Interim Head of Service  
Planning & Building Standards Service  
East Ayrshire Council  
Opera House  
John Finnie Street  
Kilmarnock

18 January 2021

**Application to discharge conditions 21/0012/AMCPP.**

Drawing Title: OFFSITE WORKS

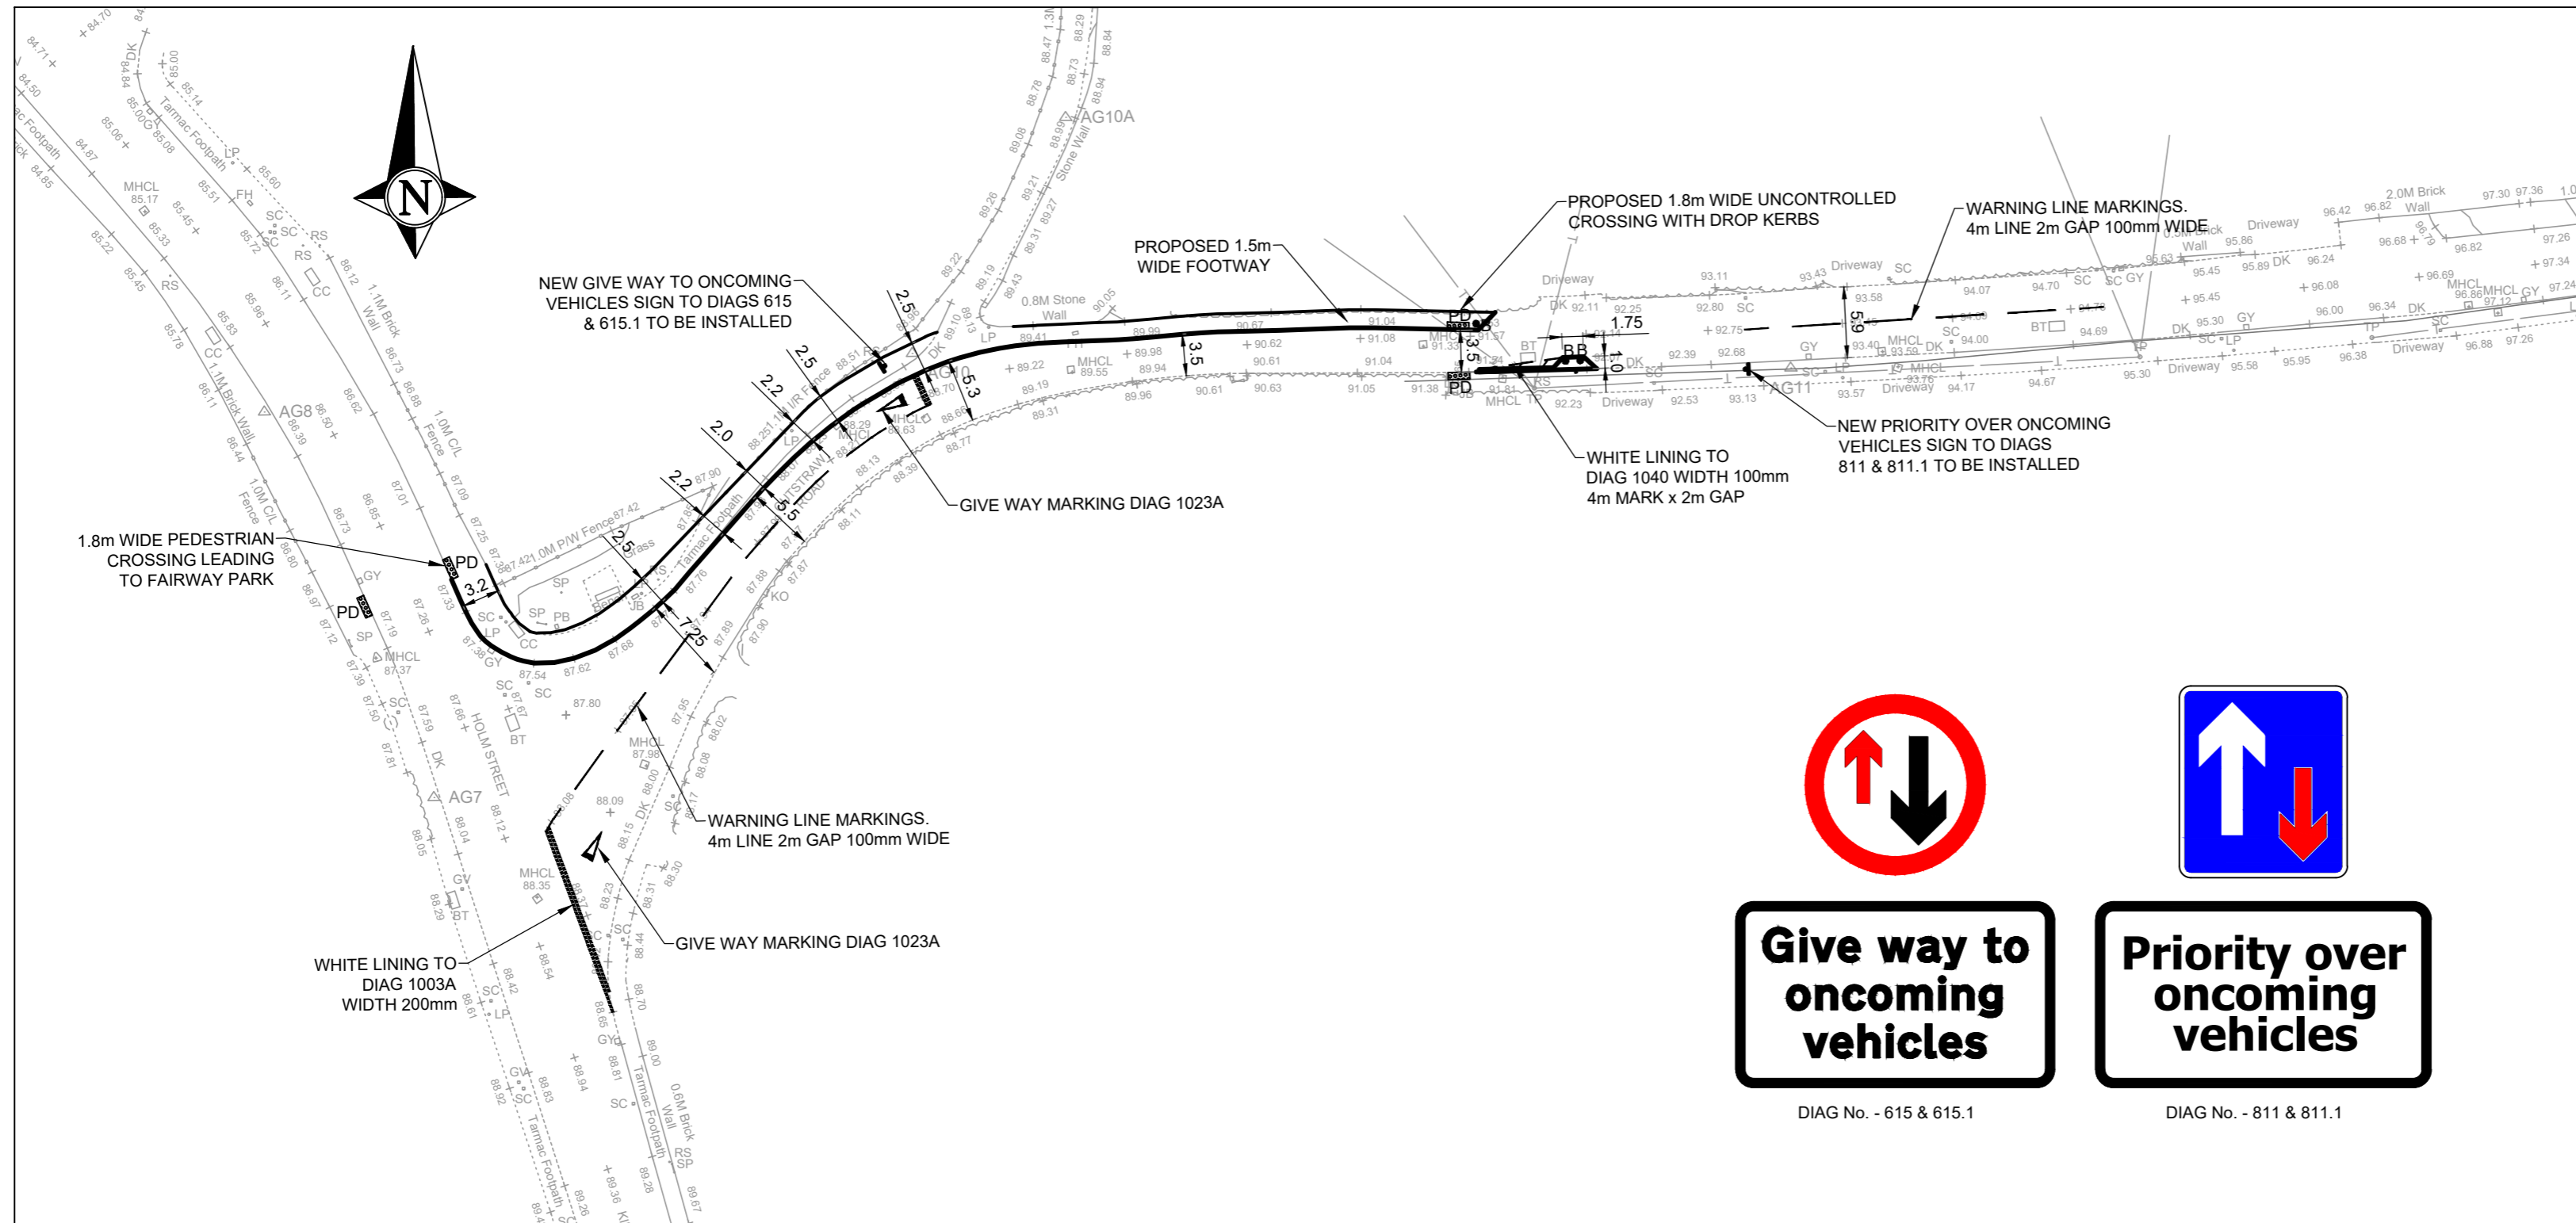
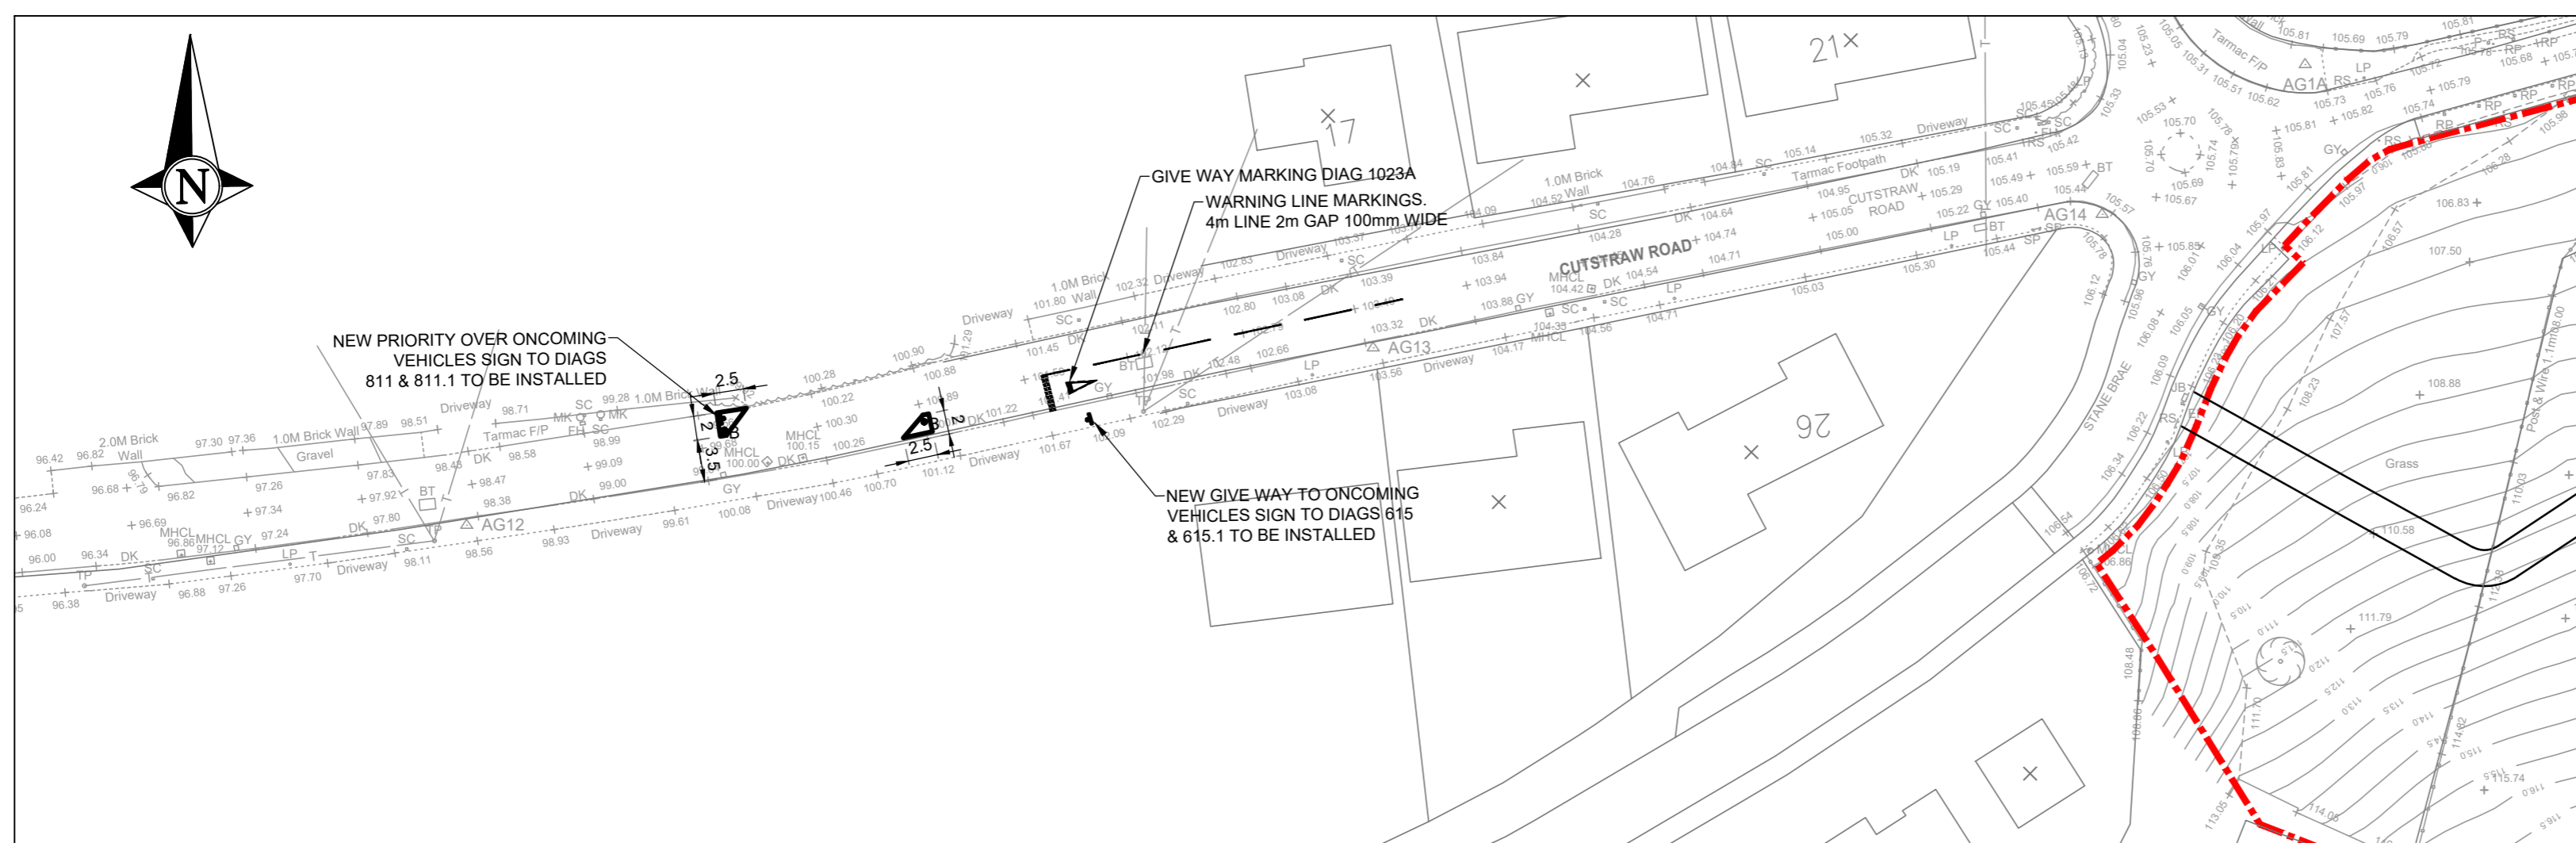
The submitted drawings detailing the traffic calming operations on Cutstraw Rd and Kirkford were required pursuant to suspensive condition 6 of 01/0859/OL but never formally submitted for approval. Consistent with previous objection, the details are now submitted to the Council out of time.

The drainage proposals may exacerbate the existing flooding problem and increase risk to Netherfield House. The Kaya flood investigation report did not fully consider this aspect, but the Planning Authority should take these matters into account to mitigate adverse impact upon neighbouring property which has already suffered one serious incident since groundworks commenced. The submitted drainage and adoption plan drawings also indicate significant earthworks, grading of land and formation of a new footpath on land adjacent to Stane Brae. These operations affect land that is under the ownership and

As the extent of earthworks, levels information and lighting details are incomplete it is difficult to determine the likelihood of light pollution affecting 23 Draffen Mount nor potential loss of privacy due to the siting and lighting of this new pedestrian route. Some cross sections would assist. The submitted adoption drawing should not be accepted without sections, a street lighting plan and explanation as to how the path is to be graded, finished ground levels, surface treatment, and information on how the route is to be maintained and insured prior to roads adoption.
